**KIRKLEES METROPOLITAN COUNCIL
INVESTMENT & REGENERATION SERVICE**

DELEGATED DECISION TO DETERMINE PLANNING APPLICATIONS

Reference No:	2025/62/90180/E
Site Address:	Dene Hollow, 20, Cliffe Road, Shepley, Huddersfield, HD8 8DF
Description:	Installation of gable end window (within a Conservation Area)
Recommending Officer:	Faiza Bano

OFFICER REPORT

PLAN A

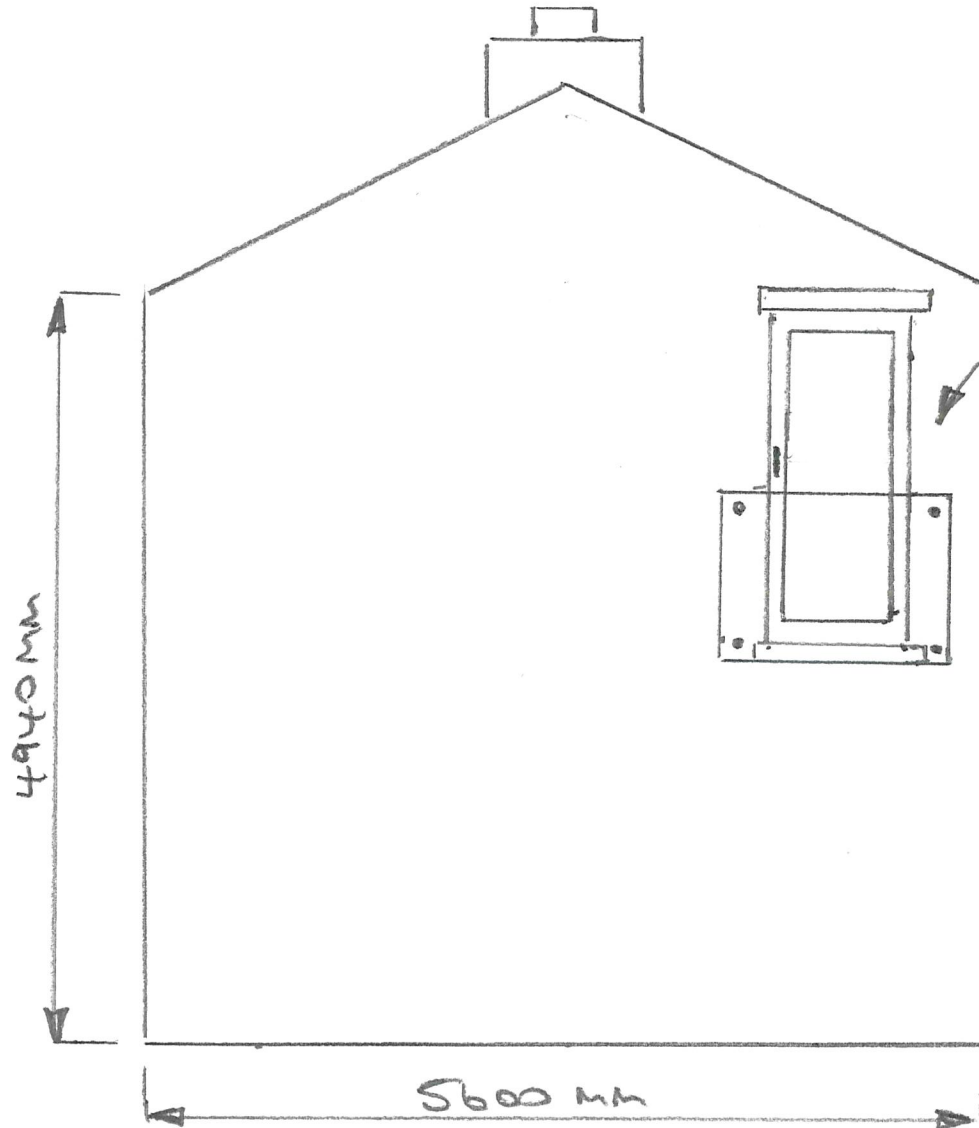
Initially, the application included the formation of a new door and Juliette balcony at the first-floor level along the gable end. However, during the course of the application process, the proposal was revised to the current plan.

- b. The privacy of the objector's property will be compromised, as part of their back garden will be overlooked.
 - c. The assertion that the door and Juliet balcony will not be visible from Cliffe Road is incorrect. An extension of Cliffe Road runs alongside the property, leading to a group of houses, from which the development will be visible.

2. The objector formally opposes the planning application to add an elevated door with clear glass to the gable end of the property. The objector asserts that this addition would impact their privacy by completely overlooking their garden and patio door. They urge that this concern be considered, and the application be refused.

3. The objector opposes the proposed new door and Juliet balcony on the gable end of No. 20 Cliffe Road, Shepley HD88DF. They argue that the elevated position of the door and balcony would directly overlook their garden, intruding on their privacy. Additionally, they contend that the relatively small gable end of No. 20 Cliffe Road makes the addition of a door and Juliet balcony appear inconsistent with the original design of the house.

- First Consultation - Although the proposed development would be on the side that does not face the main road, it would still be at a high level above a minor road within the Conservation Area, which is contrary to the SPD. The development would be highly visible, but a traditional window would be more appropriate.
- Second Consultation with amended plans – No objections.

This application has been submitted for the installation of a gable end window at the first-floor level to serve the hallway. The proposed window will measure approximately 1050mm in width and 1300mm in height, with materials matching the existing structure.

The officer's response below addresses the concerns and objections raised by the objectors regarding the proposed development at the application site. The proposal has been amended from a door and Juliet balcony to a gable end window. Each representation will be addressed individually to mitigate the concerns raised.

Amended plans replacing the door and Juliette balcony with a window.
